# CITY OF ALBUQUERQUE

**Re: L & C Transport Office and Shop/ Building A & B**  
**112 94<sup>TH</sup> St. NW**  
**30-Day Temporary Certificate of Occupancy**  
**Transportation Development Final Inspection**  
Engineer's Stamp dated 08-03-21 (K09-D043)  
Certification dated 02-27-23

L&C TRANSPORT OFFICE AND SHOP

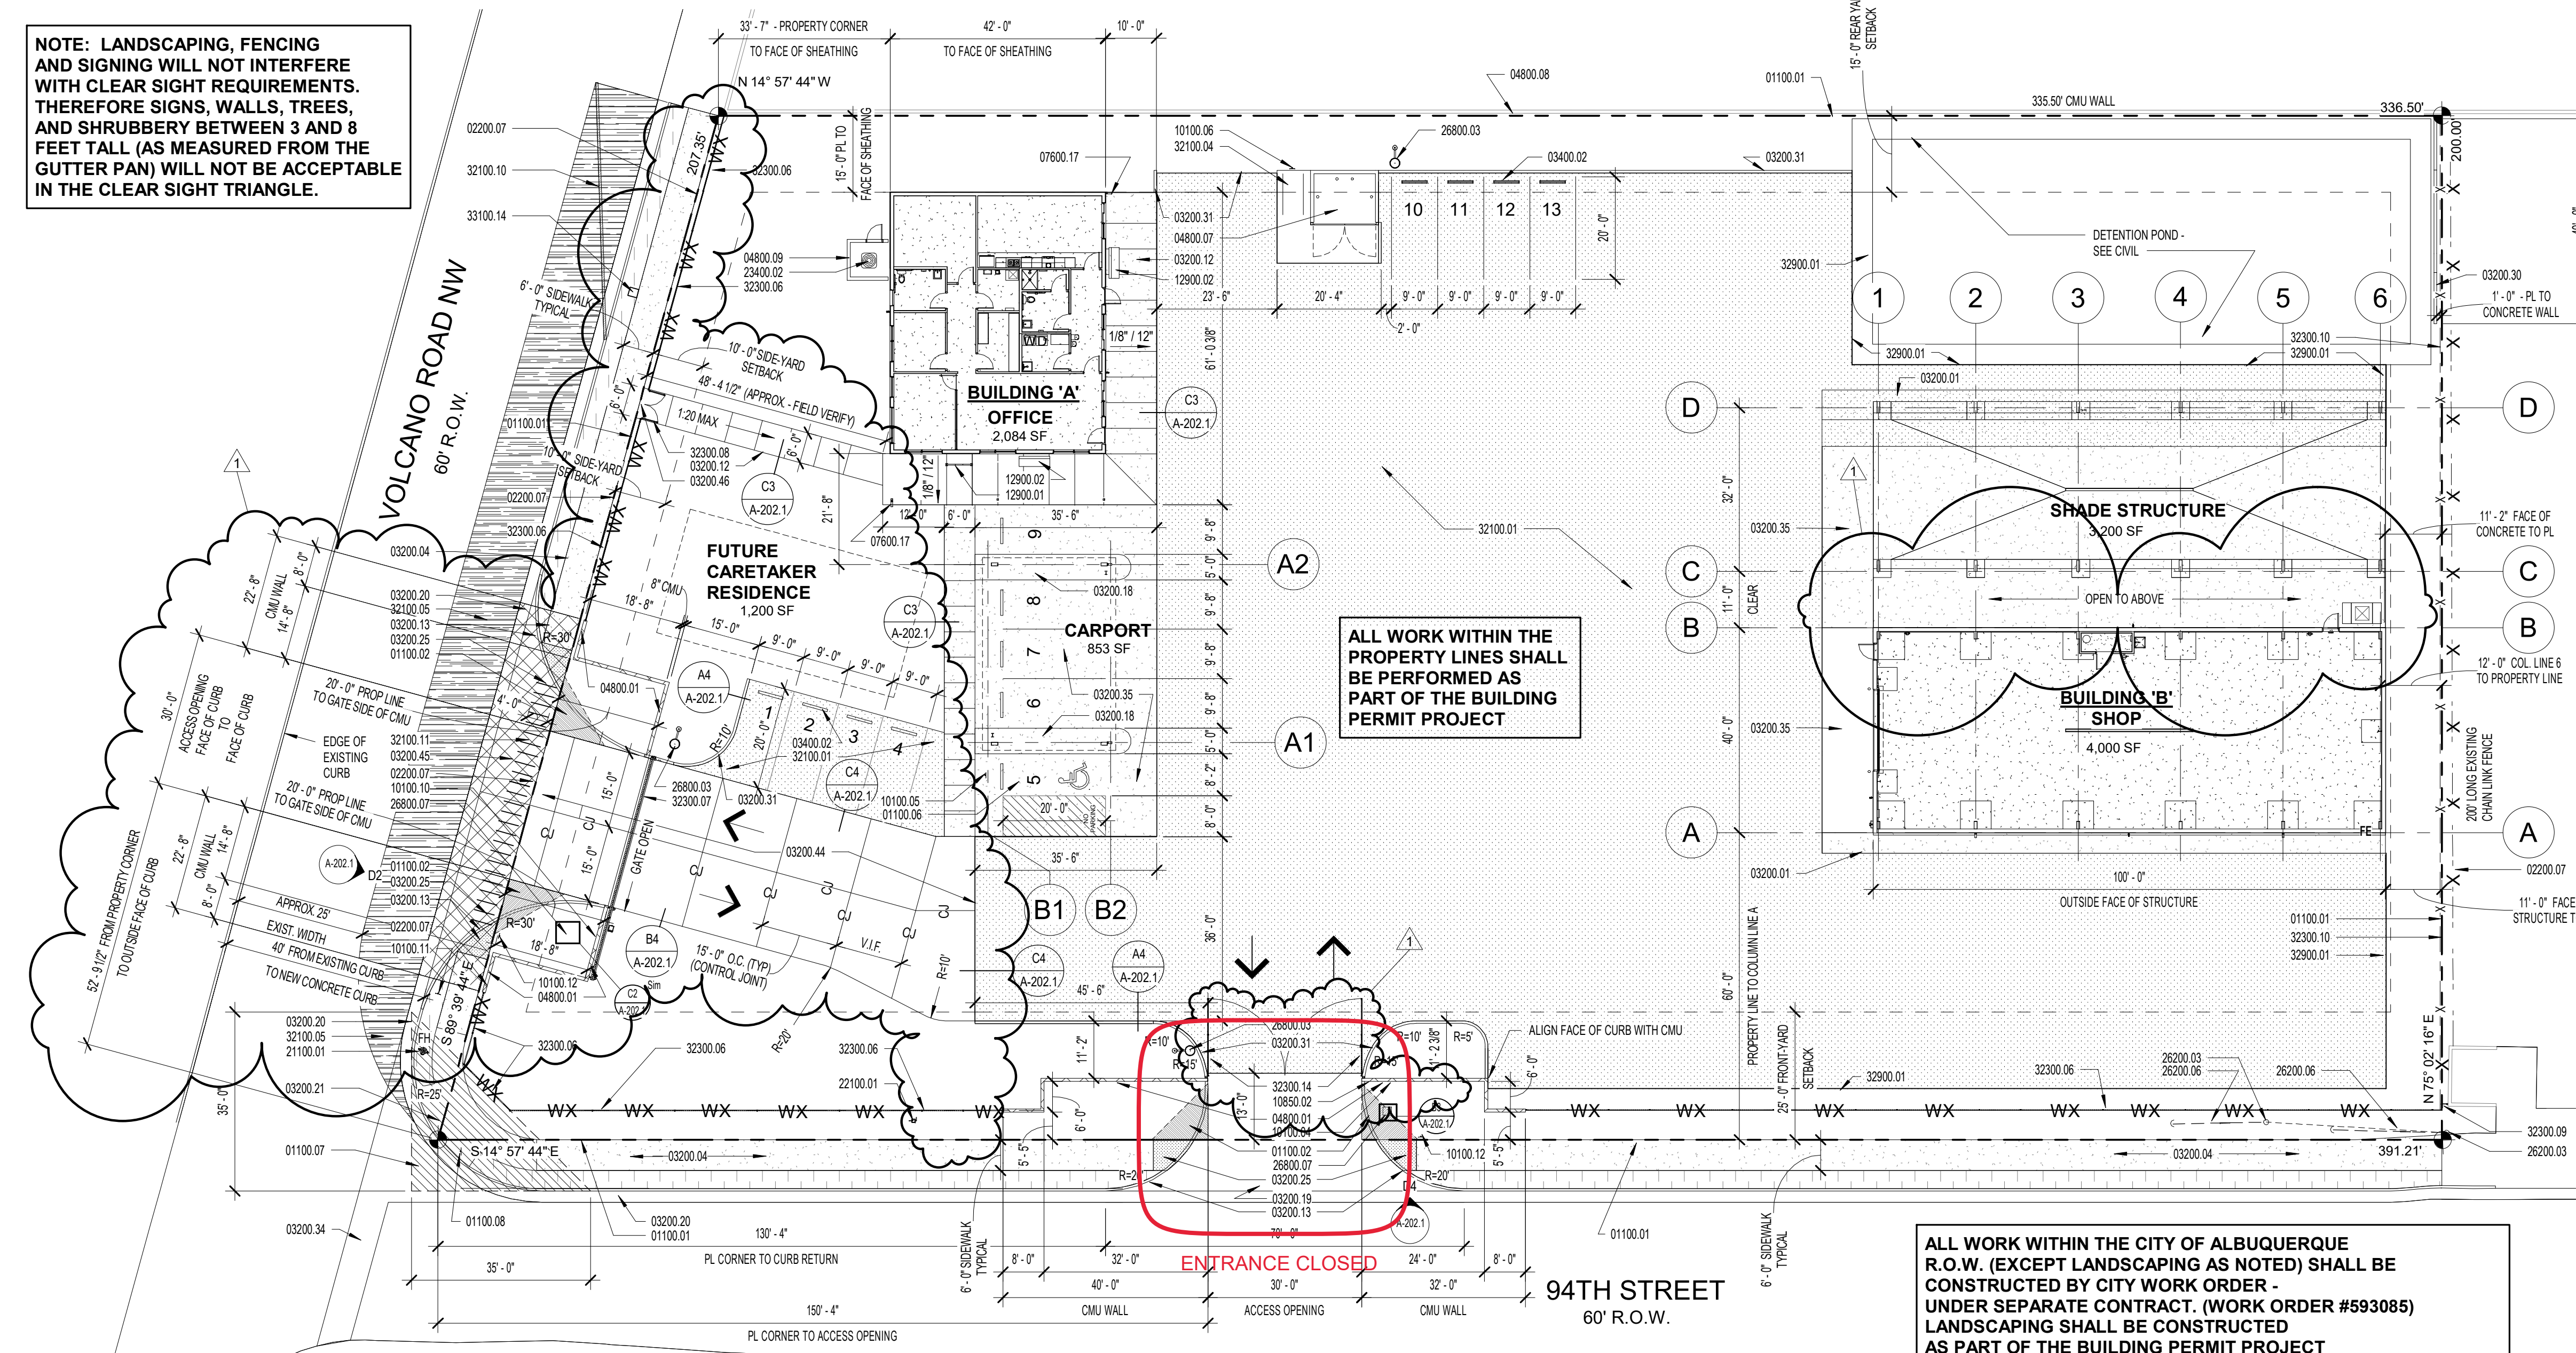
- Due to the closed gate, I couldn't measure the parking spaces.
- Please provide Motorcycle parking space. 1. Motorcycle parking spaces shall be designated by its own conspicuously posted upright sign, either free-standing or wall mounted per the zoning code. 2. The pavement marking "MC" should be shown in the opposite direction for motorcycles entering the parking space.

- The ADA access aisles shall have the words "**NO PARKING**" in capital letters, each of which shall be at least one foot high and at least two inches wide, placed at the rear of the parking space so as to be close to where an adjacent vehicle's rear tire would be placed. (66-1-4.1. B NMSA 1978)

- Per approved site plan key note 03200.46: provide 6' wide ADA pathway from the public sidewalk to the building entrance.
- Driveway access off 94<sup>th</sup> must be built per approved plan.
